**PROJECT#** 1002238

**AGENT:** MULLER INDUSTRIAL SUBDIVISION

4. **Project# 1002238**  
15DRB-70238 MINOR - PRELIMINARY/  
FINAL PLAT APPROVAL

**RE: Tract 2-A, Muller Industrial Subdivision**

PLAT OF  
TRACT 2-A-1 AND 2-A-2  
MULLER INDUSTRIAL SUBDIVISION

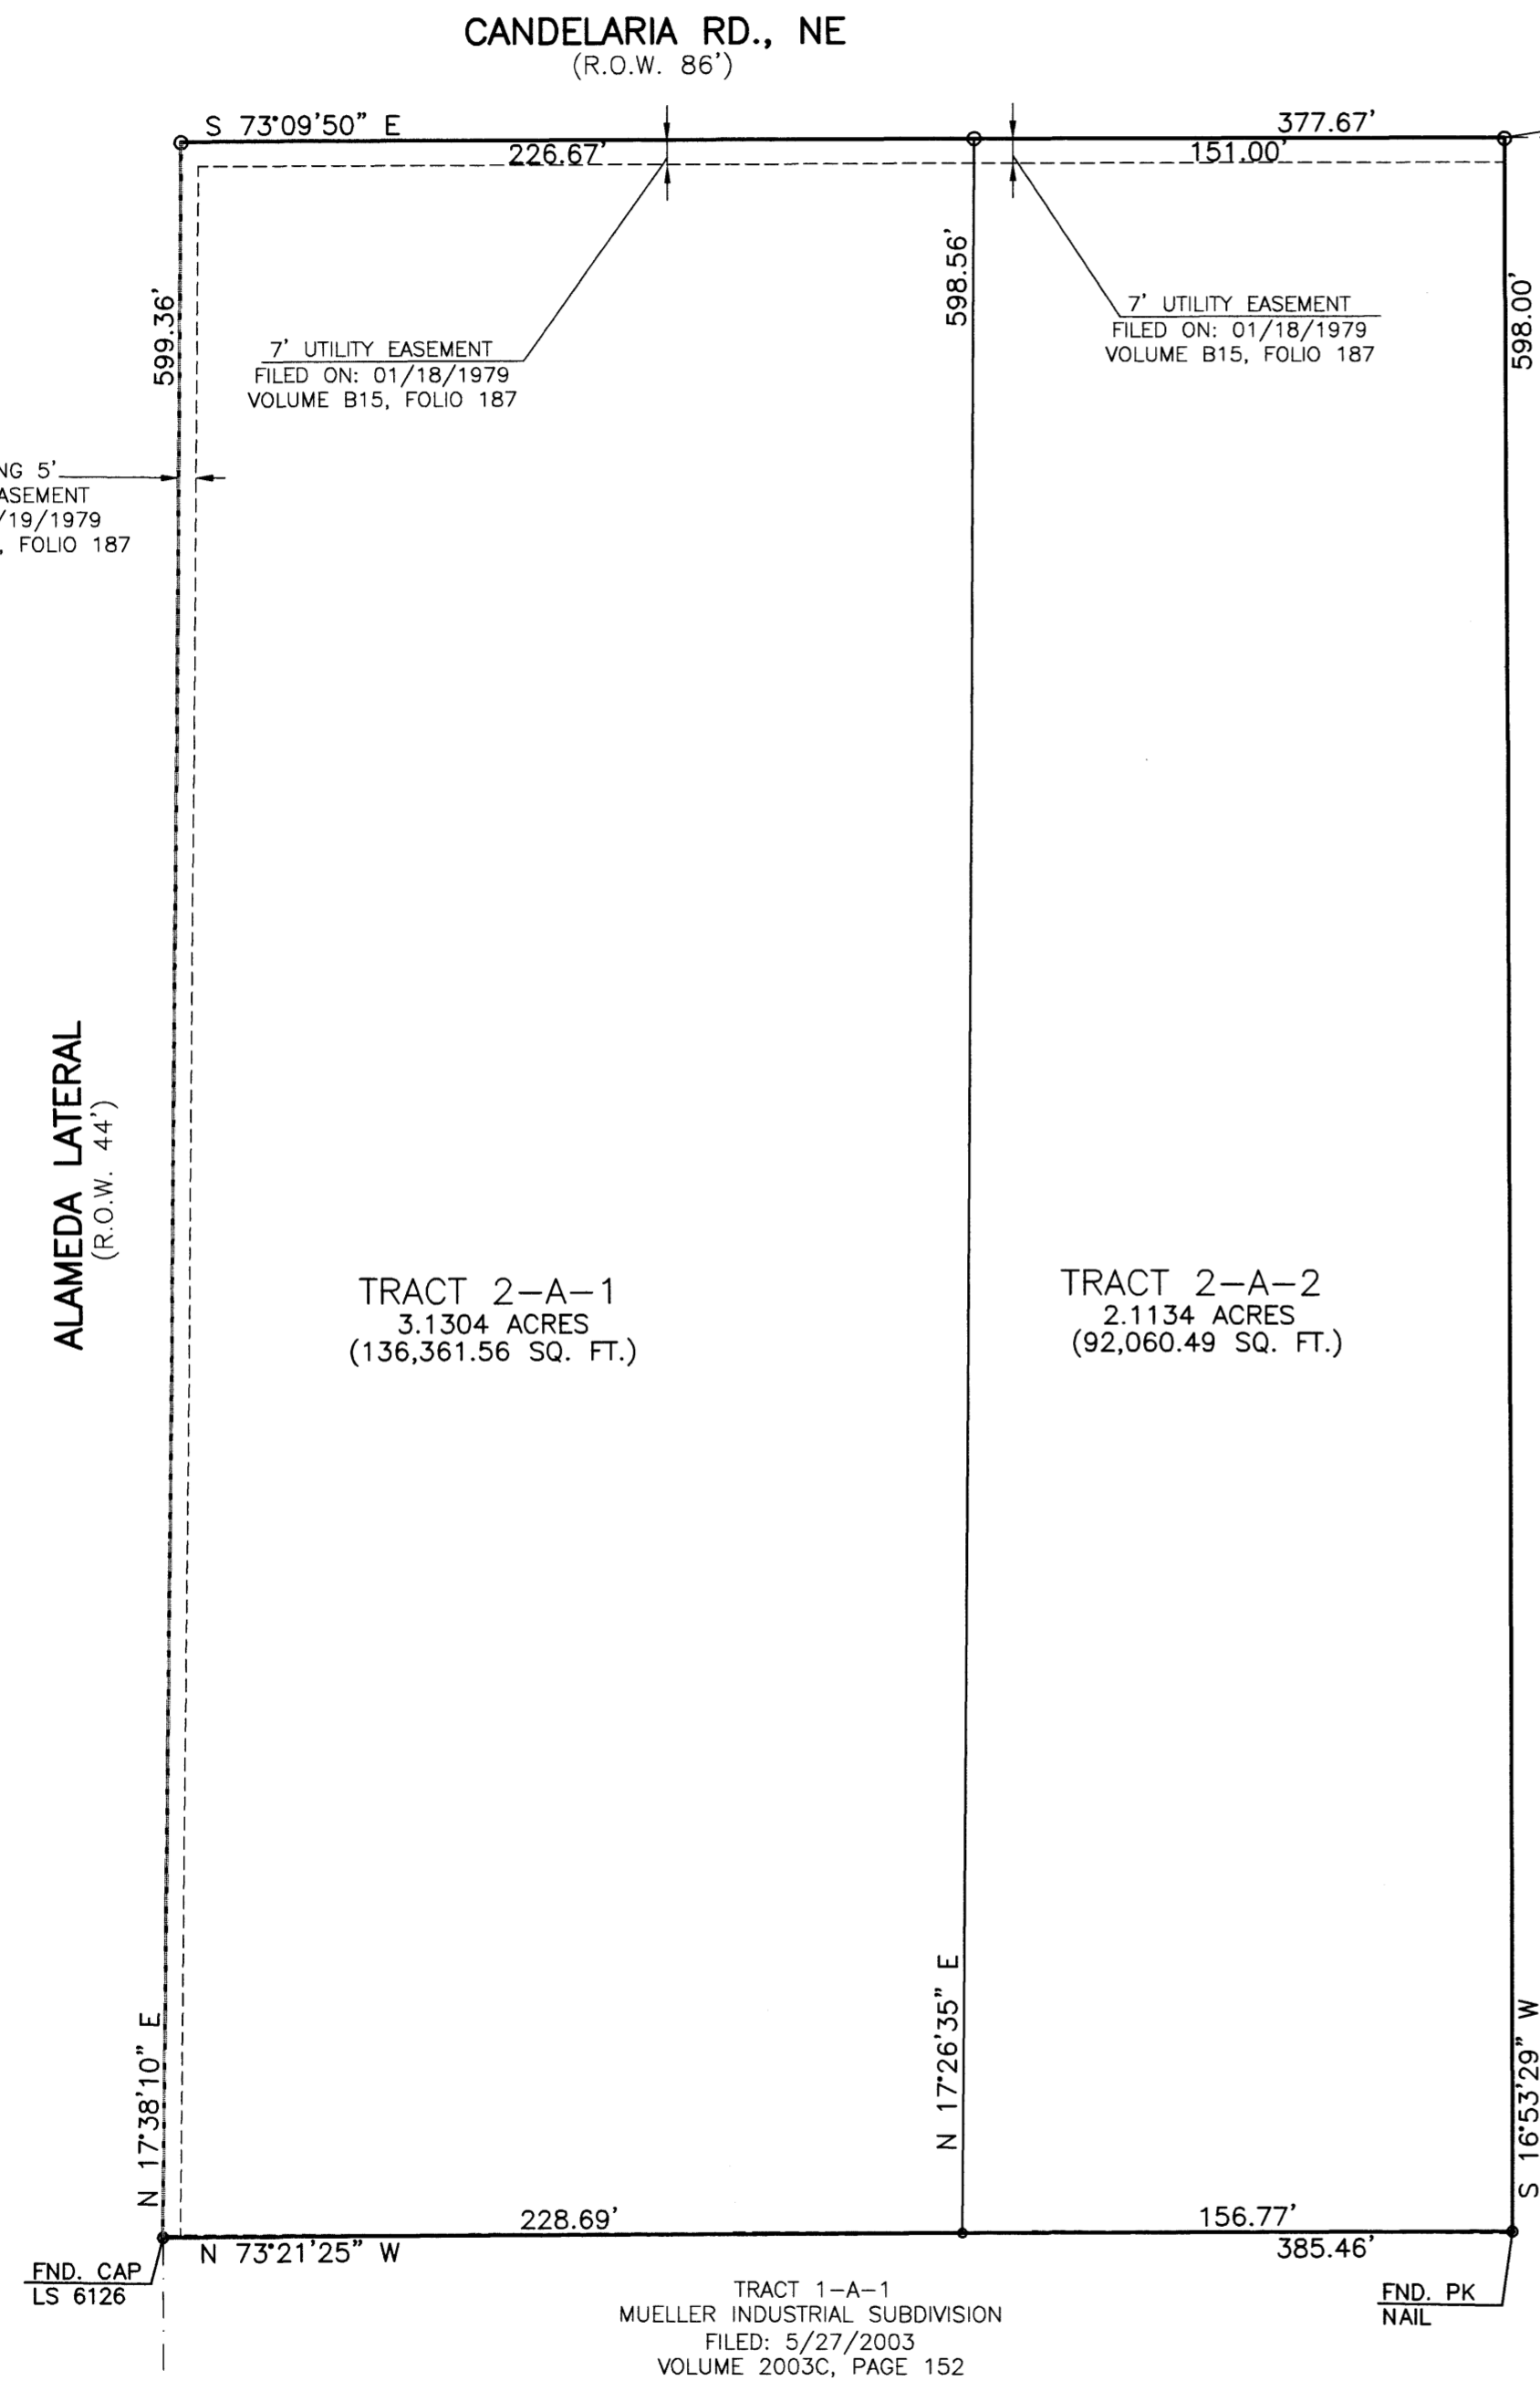
Per the **Definitions** in the Zoning Code, this parcel is designated a Shopping Center site (SC):

Per the Subdivision Ordinance, an approved site development plan is required prior to platting:

- (a) A site development plan must be approved prior to platting; and
- (b) The plat must conform to the approved site development plan.
